Subject: RE: Planning Consultation on: Y/50/20/DOC

Engineers Comments Regarding Surface Water Drainage

Application No: Y/50/20/DOC
Registered: 10th June 2020
Site Address: Rookery Cottage Hoe Lane Flansham PO22 8NT
Description of Works: Approval of details reserved by condition imposed under ref Y/72/19/HH relating to Condition No 3 - surface water drainage.

B	Revised Issue	07/07/2020
A	Original Issue	28/05/2020
Rev.	Amendments	Date

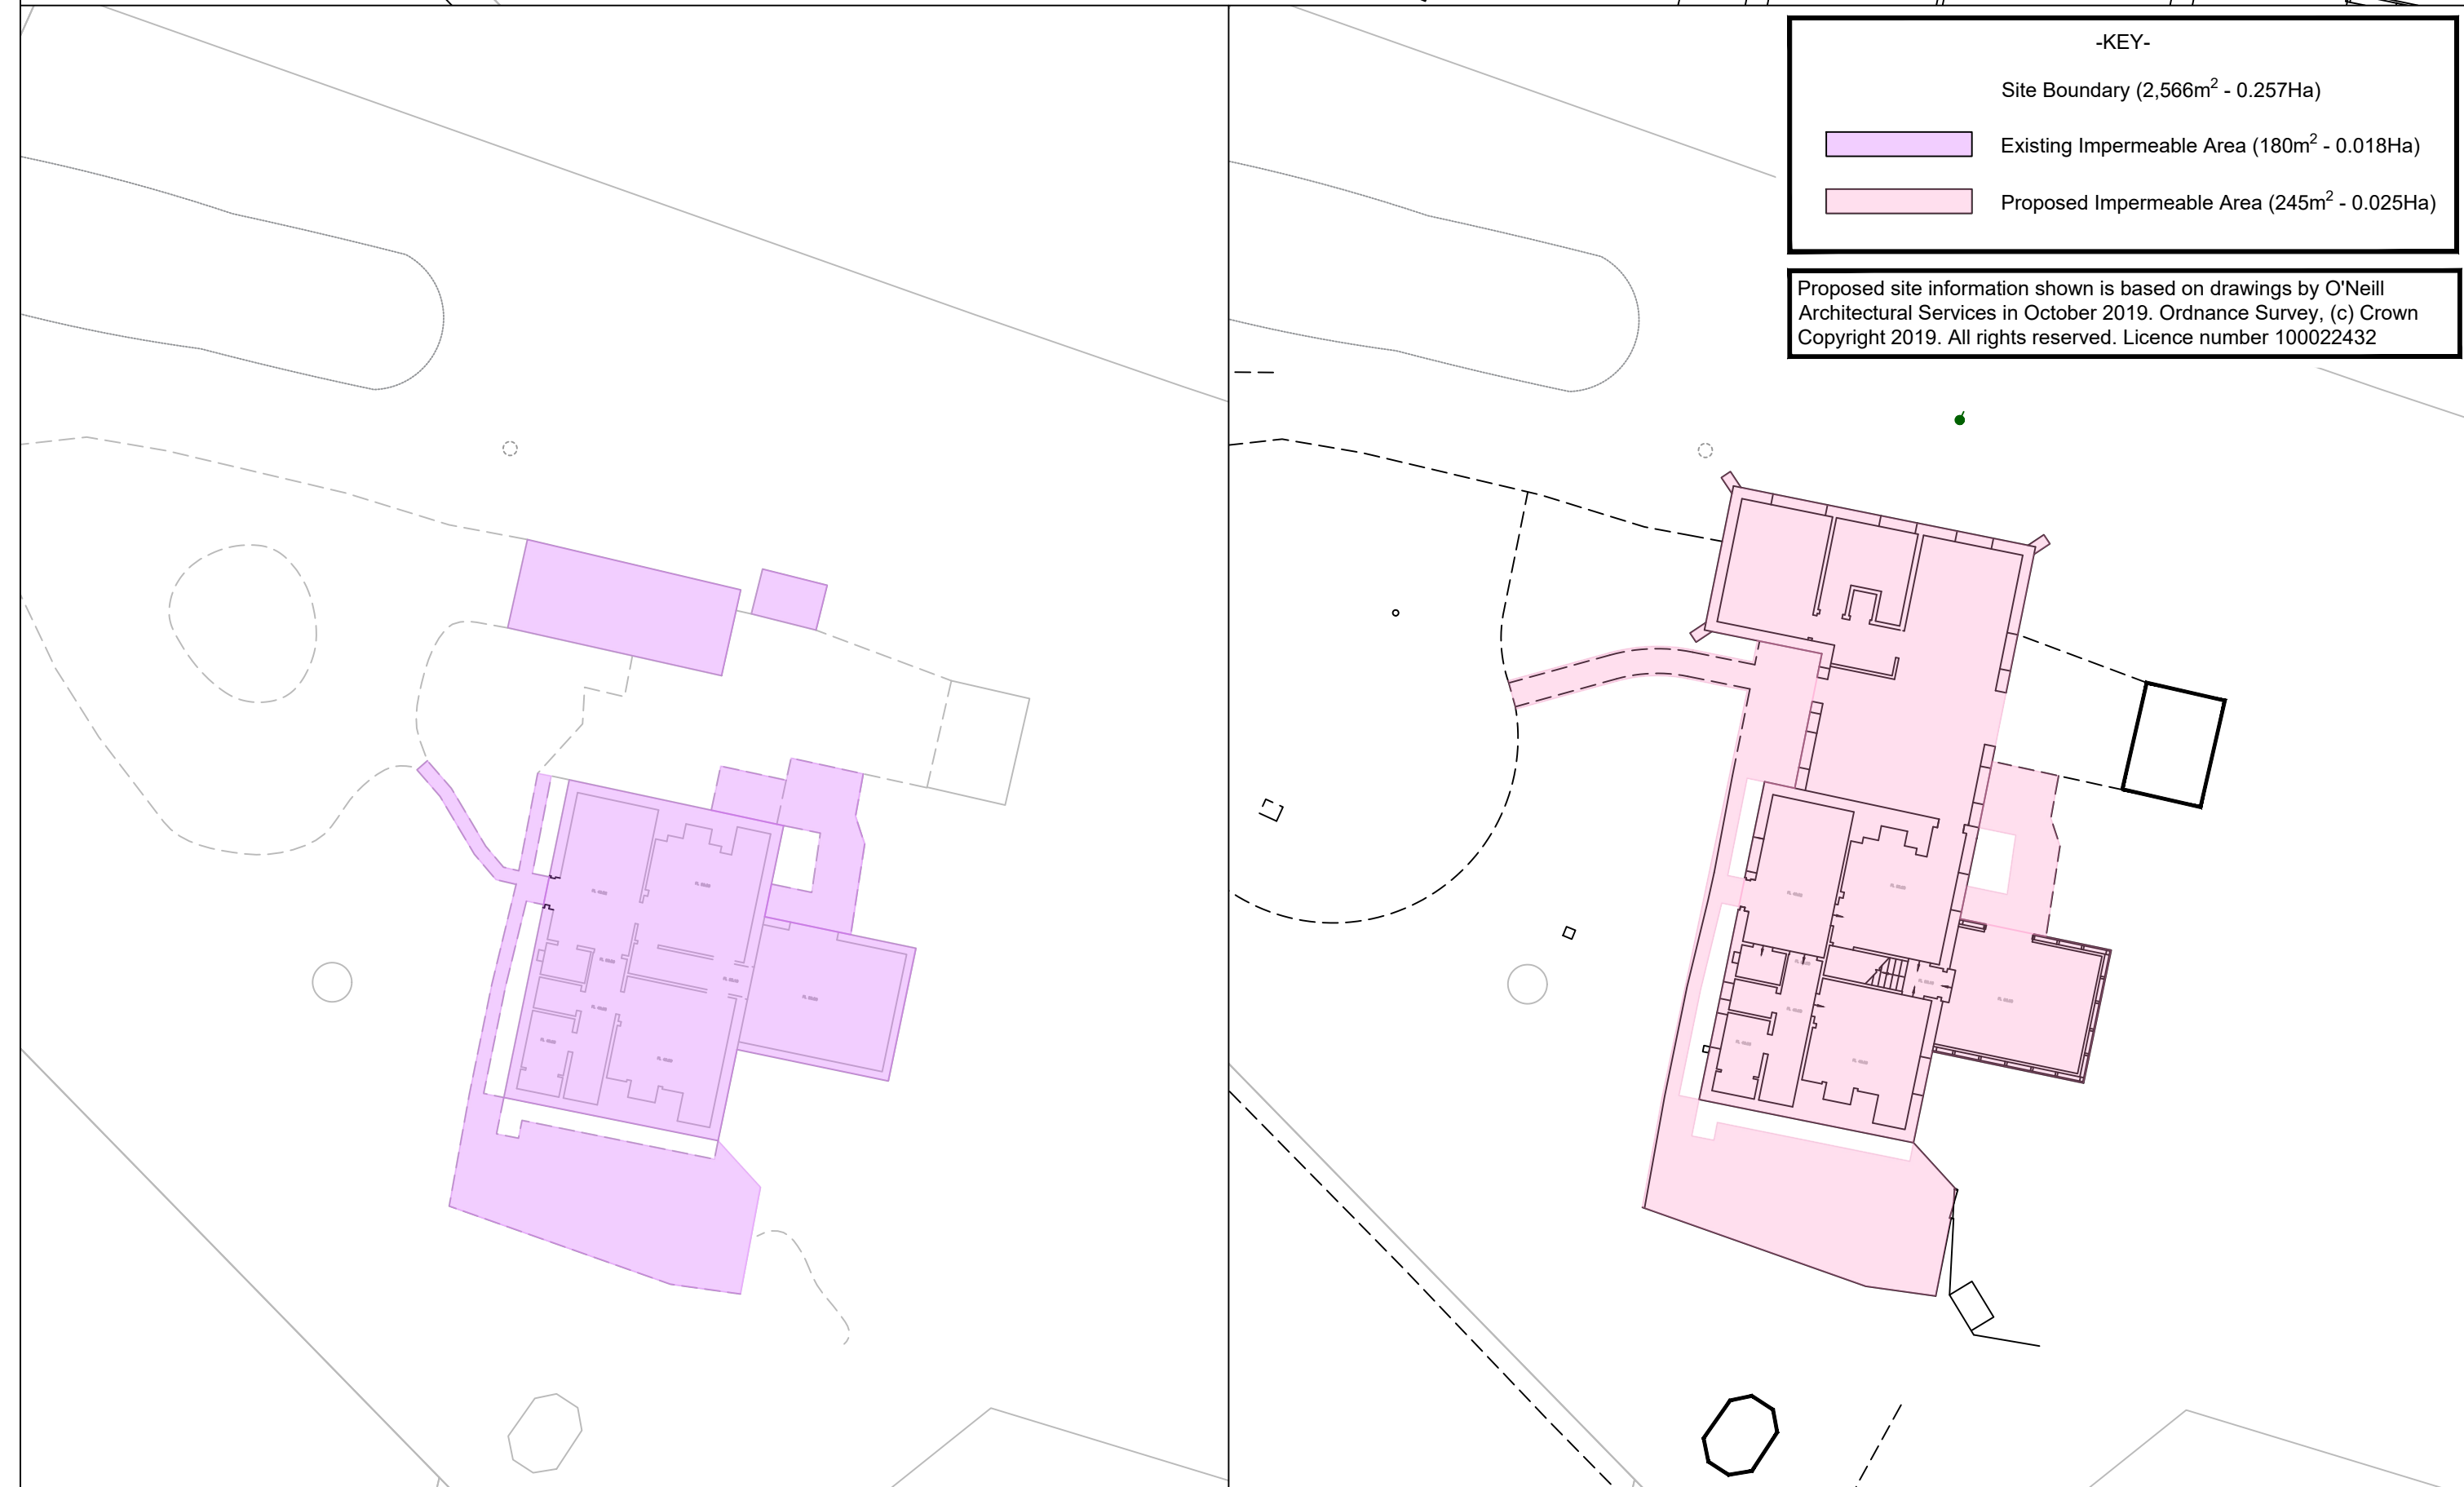
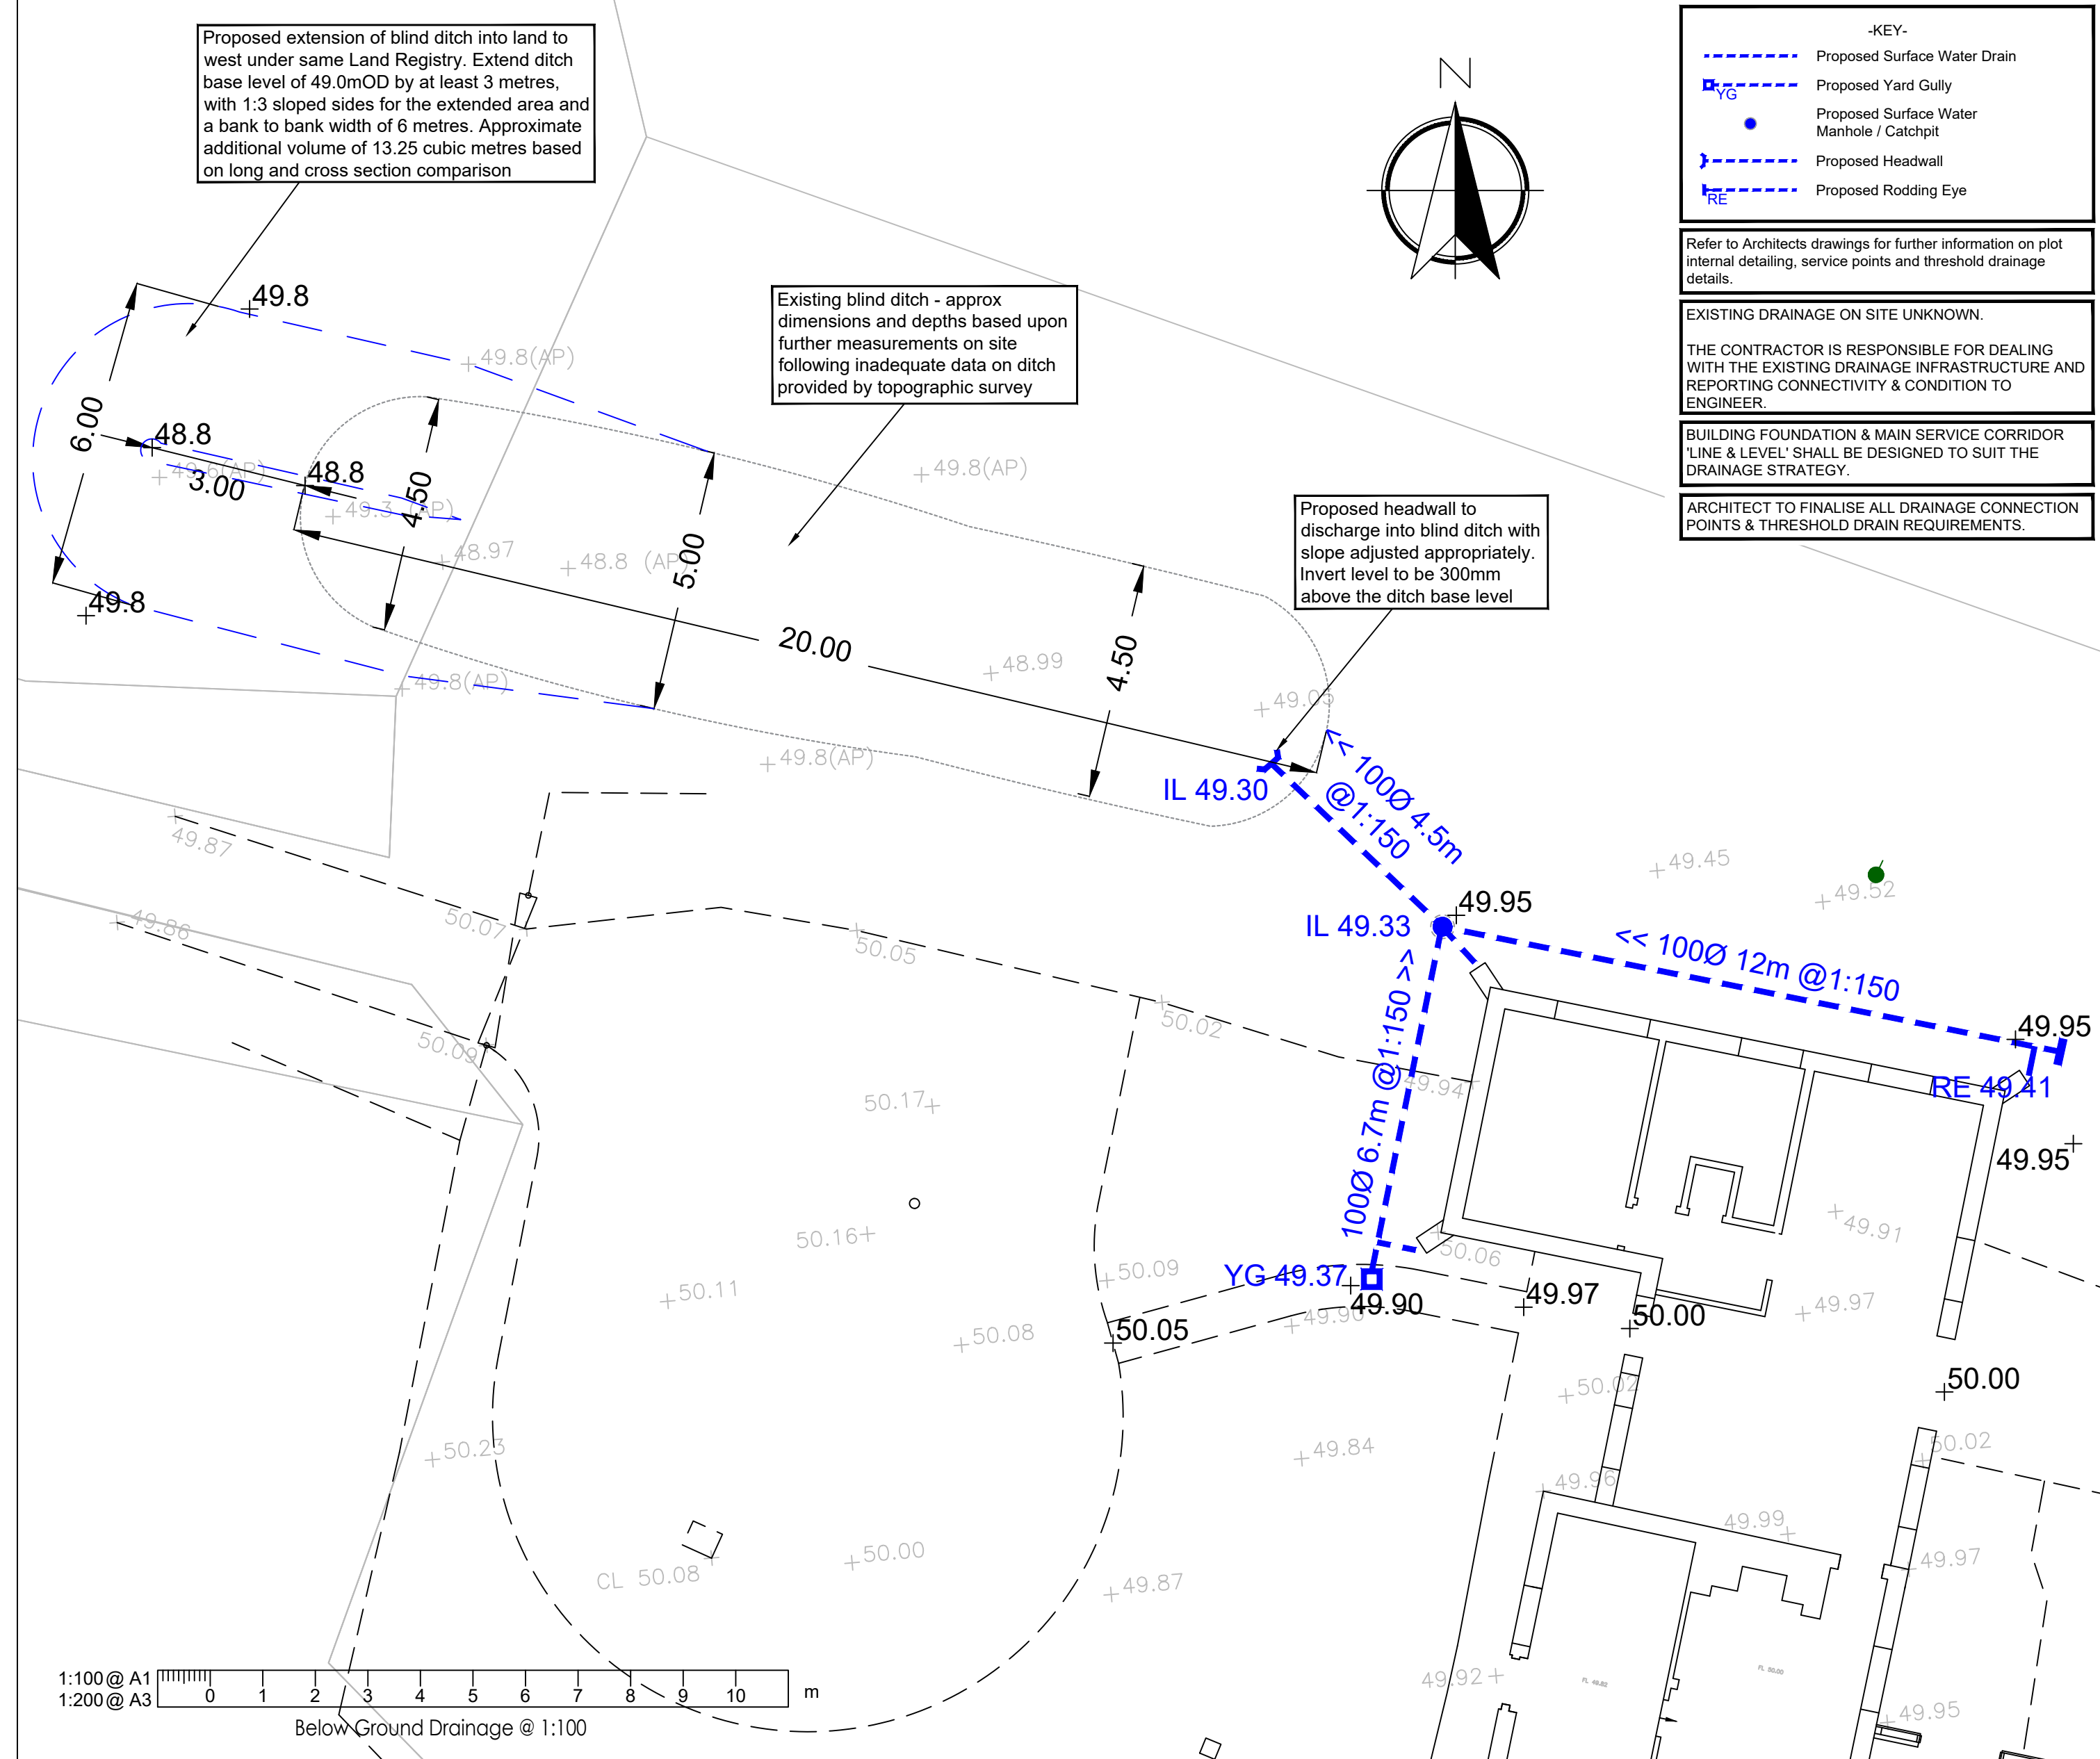
Please amend the inspection chamber to a catch pit (provide a sump). Once this is done I will be happy to recommend discharge of condition 3.
